**WELWYN HATFIELD BOROUGH COUNCIL
DIRECTORATE OF STRATEGY AND DEVELOPMENT**

DELEGATED APPLICATION

Application No: 6/2016/0398/HOUSE
Location: 35 Kentish Lane, Brookmans Park, Hatfield, AL9 6NG
Proposal: Conversion of existing loft space including addition of new dormer windows & roof light, external alterations to include reduction of portico, change to fenestration, change of roof finish from plain clay tiles to slate and addition of stone sills and quoins.
Officer: Ms L Hale

Recommendation: Granted

Drawing Title
Proposed Floor Plans

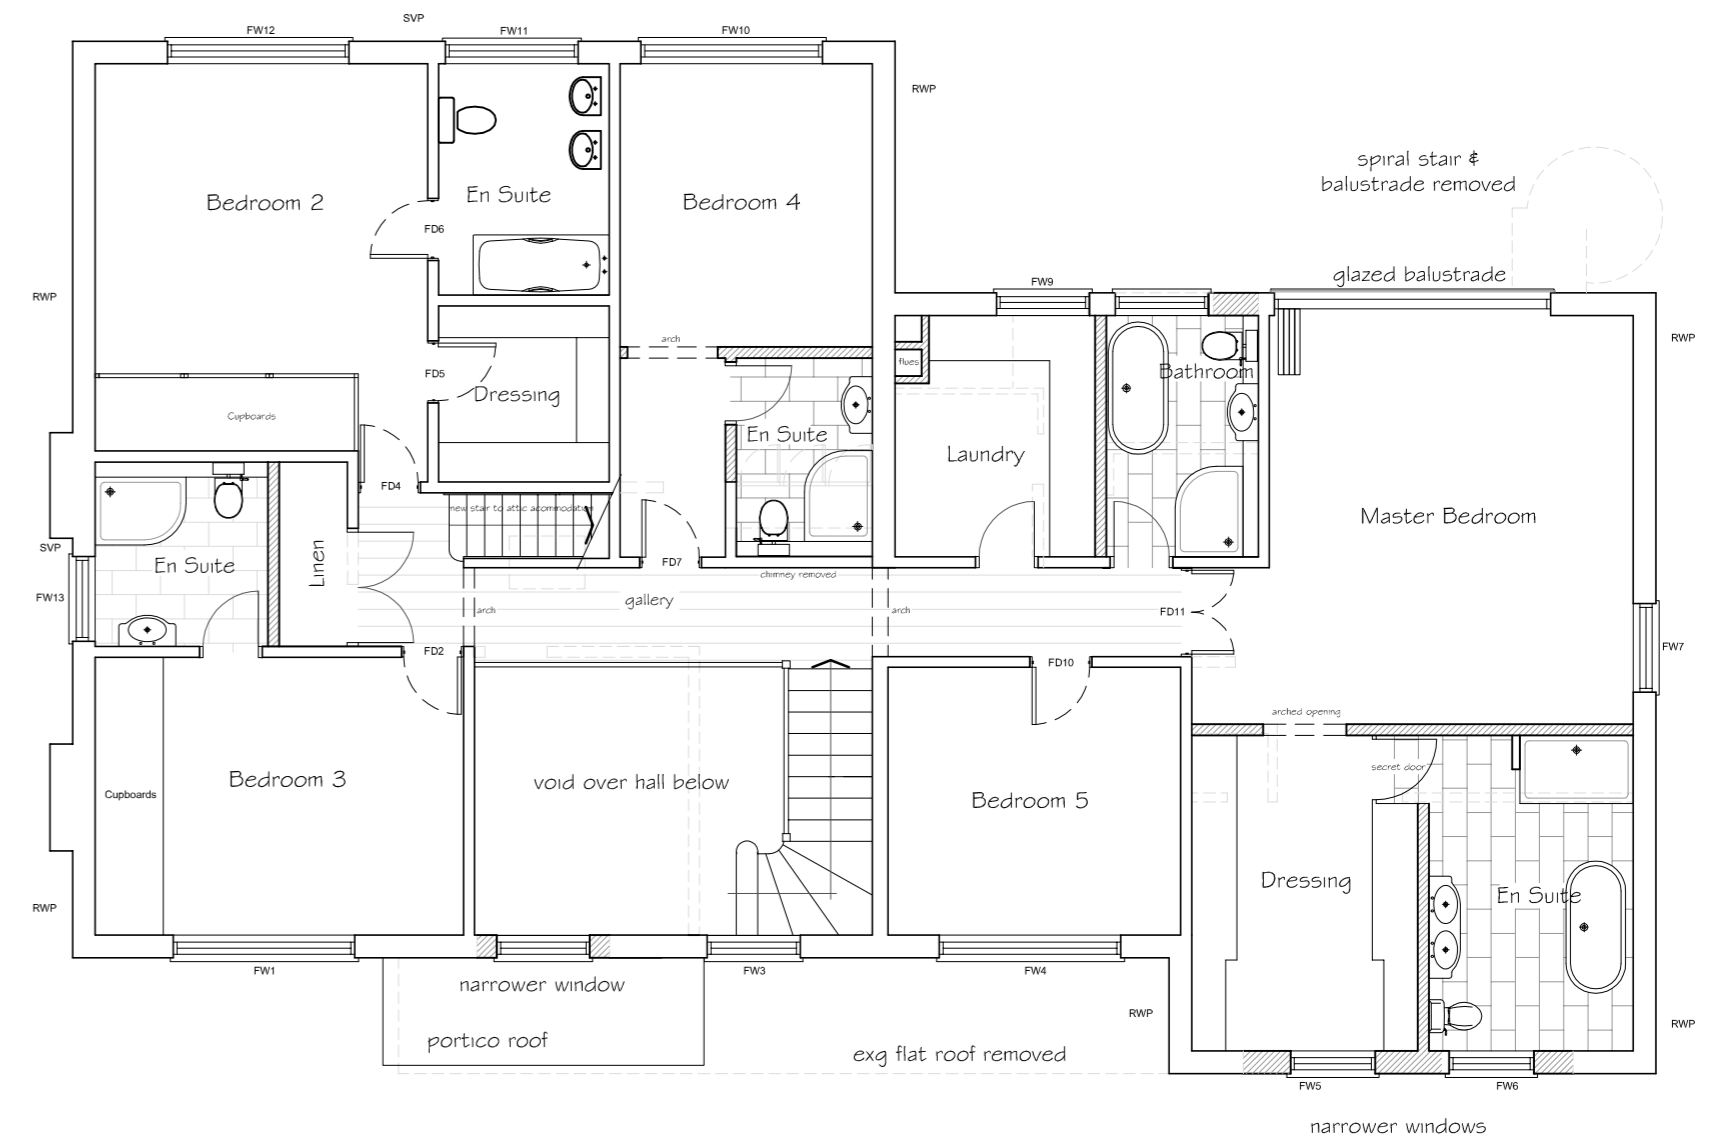
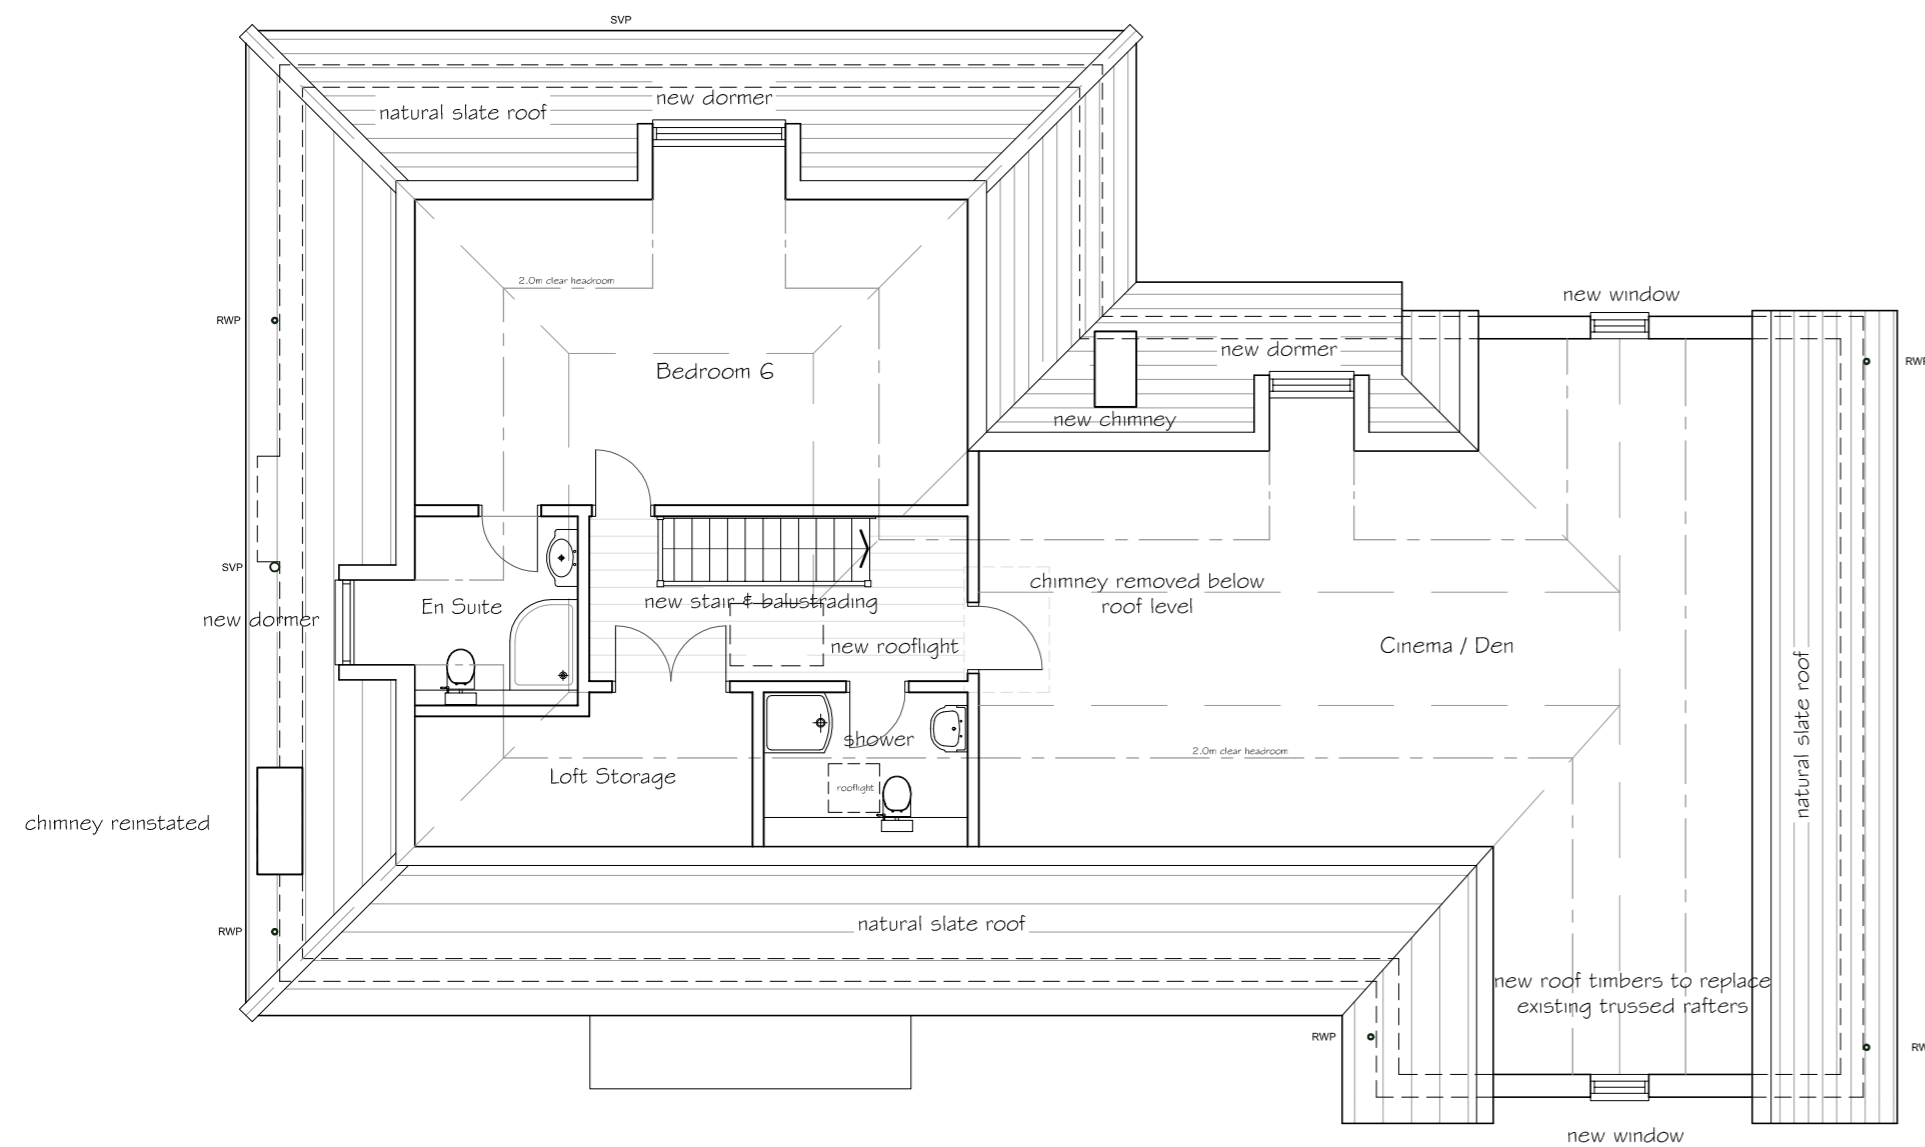
The applicant seeks permission for the conversion of existing loft space including addition of new dormer windows and a roof light. The Supplementary Design Guidance outlines that dormer windows should be contained within the roof slope be subservient to the roof of the property and be in proportion of the existing fenestration of the property. They must not extend above the ridge height of the existing dwelling and the dormer cheeks should be at least 1 metre from the flank wall of the property. The proposed dormer windows would be within the roof slope of the rear elevation and would be set in from either flank wall, and set down from the ridge. The proposed dormer windows are considered to match the proposed fenestration detailing of the existing property, additionally they are proposed on the rear elevation and so will not be visible from a public vantage point. Therefore, the dormer windows are considered to maintain the character of the existing property and are considered to be acceptable in this regard. Additionally the applicant seeks permission for a roof light to be located in the centre of the front elevation. There is evidence of roof lights within the street scene of Kentish Lane and so the proposed roof light is not considered to detract from the character of the existing property or the surrounding area.

towards the host property which is obscure glazed as it serves a bathroom. Additionally, the proposed side facing dormer window will also be obscure glazed as it will serve an en suite bathroom. Therefore, it is not considered that the proposed dormer will have a detrimental impact on the residential amenity of No.33 Kentish Lane in terms of overlooking or loss of privacy.

Drawing Title
Proposed Elevations

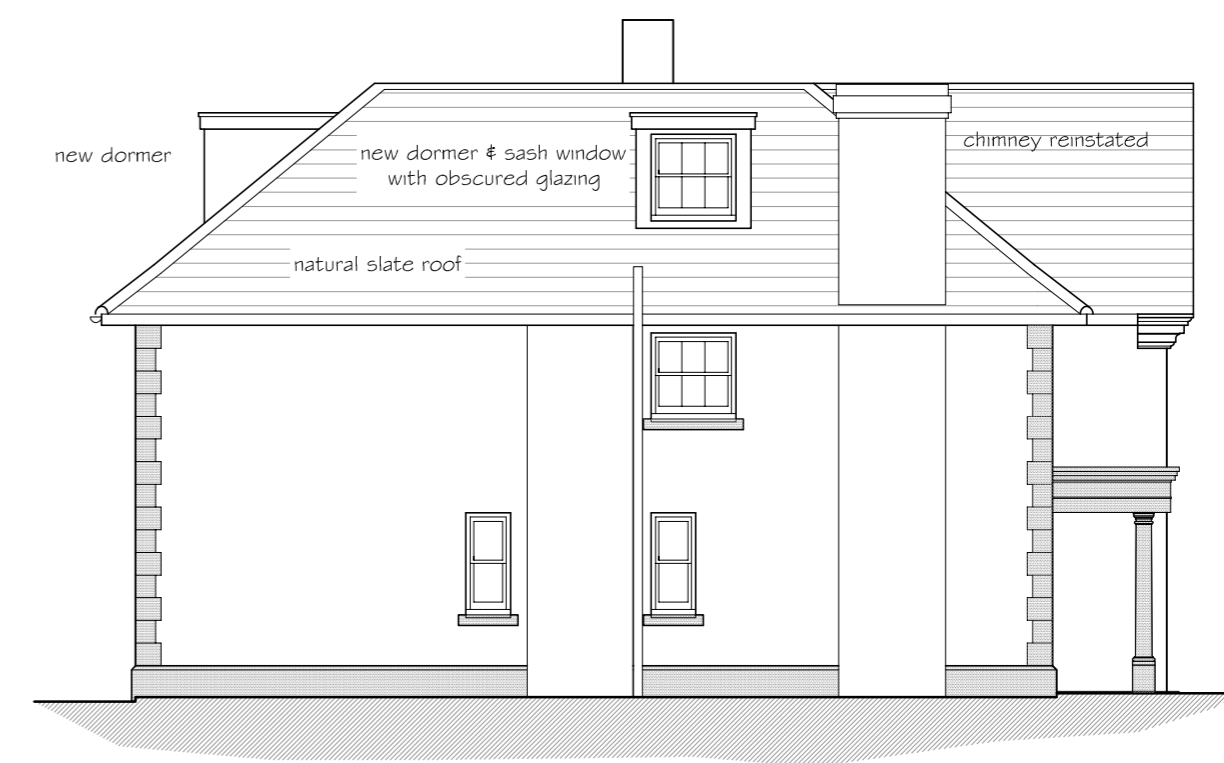
The applicant also seeks permission for additional windows and change to the positioning, scale and detail. The existing windows are painted timber casements, and the applicant seeks to replace these with timber sash windows with stone sills as well as the existing door painted timber panelled doors and painted timber glazed doors which are proposed to be painted timber panelled doors and powder coated aluminium sliding doors. The proposed detailing will reflect throughout the dwelling. Therefore, it is considered that the development would not detract from the character of the dwelling or streetscene.

The applicant also seeks permission for a re-instated chimney and a new chimney on the rear elevation which would be visible from the street scene, however they are not considered to significantly detract from the character of the dwelling to warrant a refusal.

The applicant also seeks permission for the addition of stone sills and quoins, and a change of roof finish from plain clay tiles to slate. With the addition of the changes to the fenestration detailing, the exterior of the property will change in character to its existing form. However, given the street scene of Kentish Lane which features properties of a variety of style and design. The proposed changes are not considered to detract from the character and appearance of the host dwelling or nearby locality. The development is, therefore, not contrary to policies RA3, D1, D2 of the adopted Welwyn Hatfield District Plan 2005, the adopted Supplementary Design Guide and Section 7 of the NPPF.

The applicant proposes the insertion of two dormer windows and an additional window to the rear of the property. The proposed dormers are not considered to result in significant harm to the occupiers of neighbouring properties in terms of overbearing and loss of light. They would not afford direct views of primary private amenity space; the proposed dormers would preserve the privacy of the neighbouring occupiers.
